An
Bord
Pleanála

Inspector's Report ABP-304220-19

Whether the use of lands for purposes ancillary to the enjoyment of the dwelling house, agricultural purposes and commercial/vehicle storage purposes is or is not development or is or is not exempted development at Knockloughlin, Longford, Co. Longford

DC 19/3

Photo No 5 - 26 Cars parked in bog area

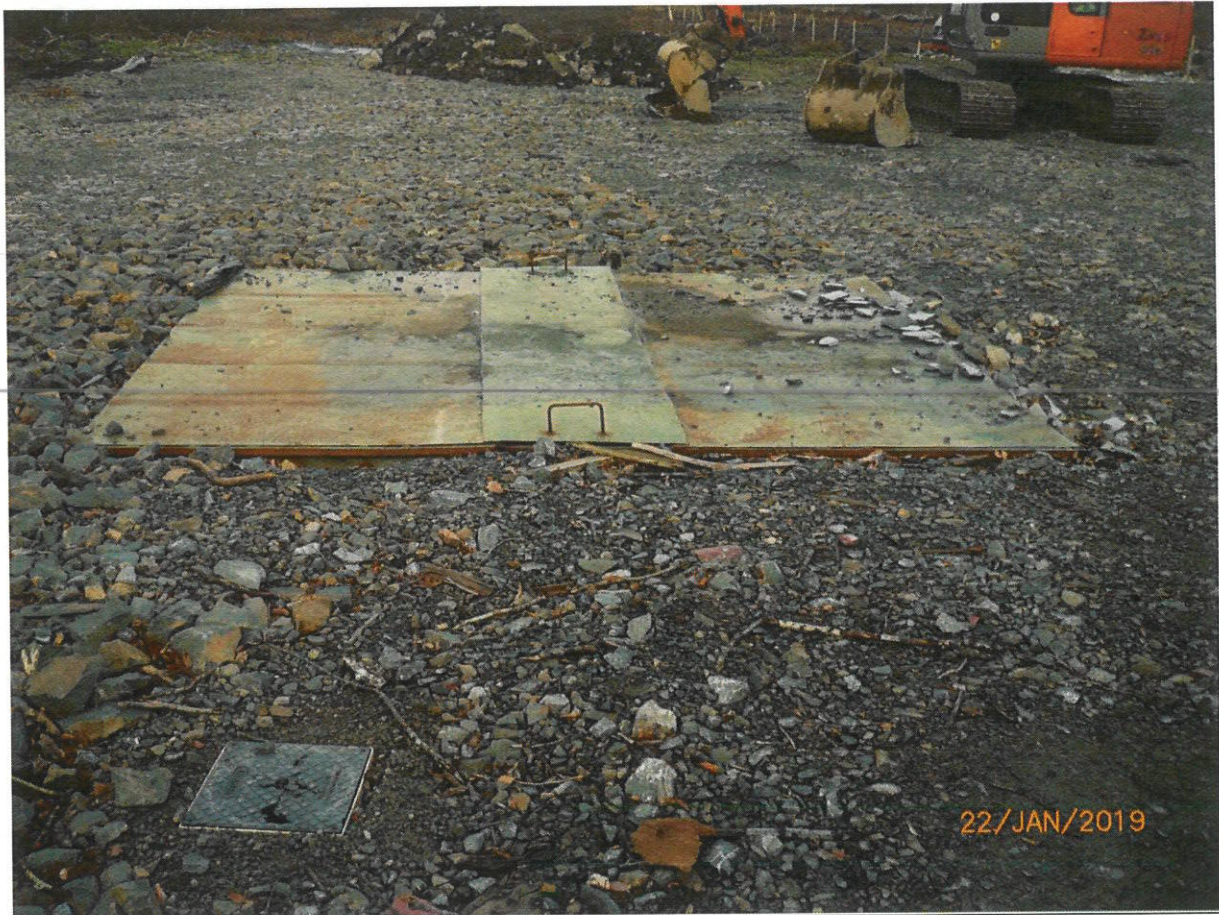
- 8.3.15. At the time of site inspection, there were no scrap cars in the bog area to the north of the subject site but there were a mix of vehicles parked to the north east of the residential dwellings.

- 8.3.16. With respect to the storage of scrap cars, the Planning and Development Regulations 2001 (as amended) are clear, where land becomes used for the deposit of vehicles (whether usable or not), the use of the land shall be taken as having materially changed. There are no exempted development provisions for this material change of use and I would consider, therefore, that in principle this development (although not observed) is not exempted development.

Photo No 8 - Shed containing Car lift & Toilet Block

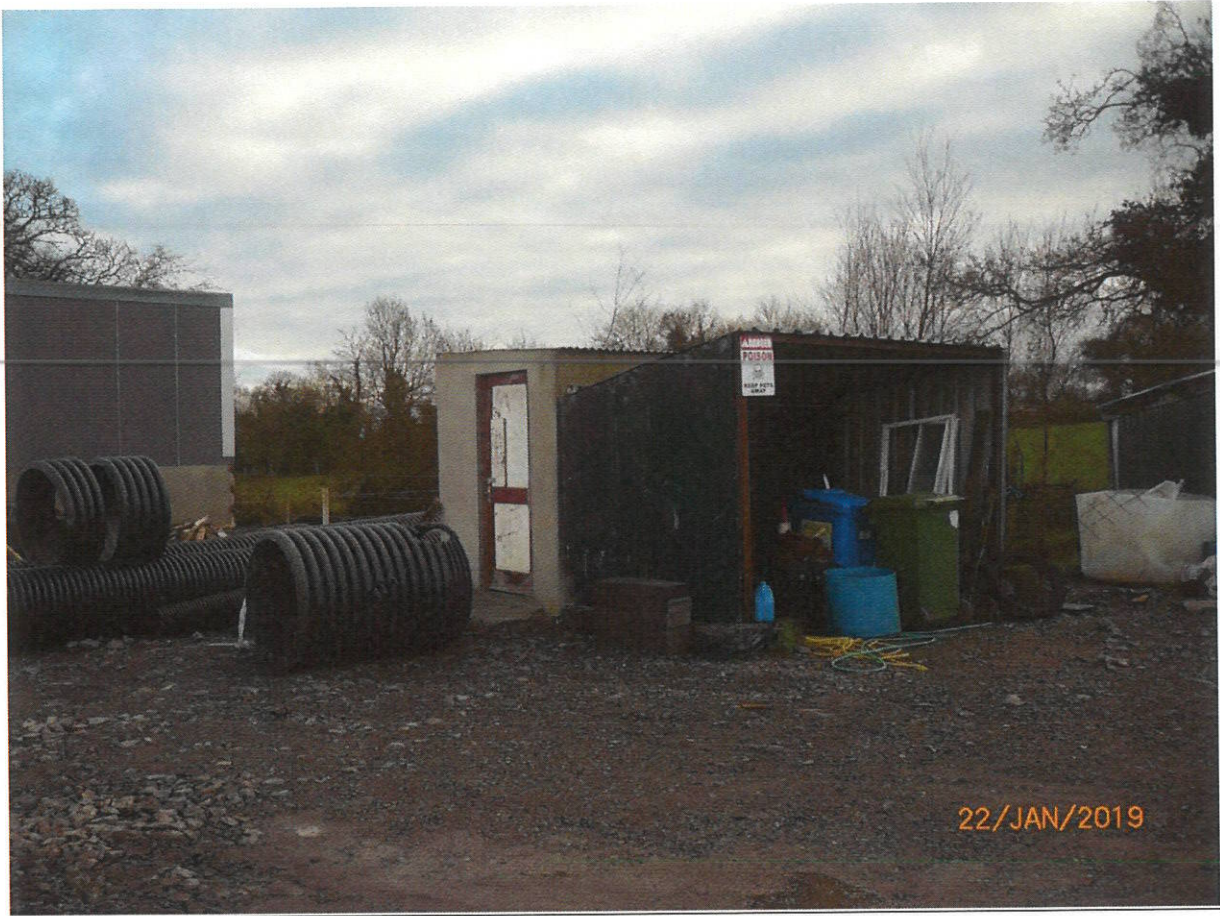
- *Shed containing car lift and toilet block* – Shed is being used for repair of cars parked onsite and does not constitute an agricultural structure.
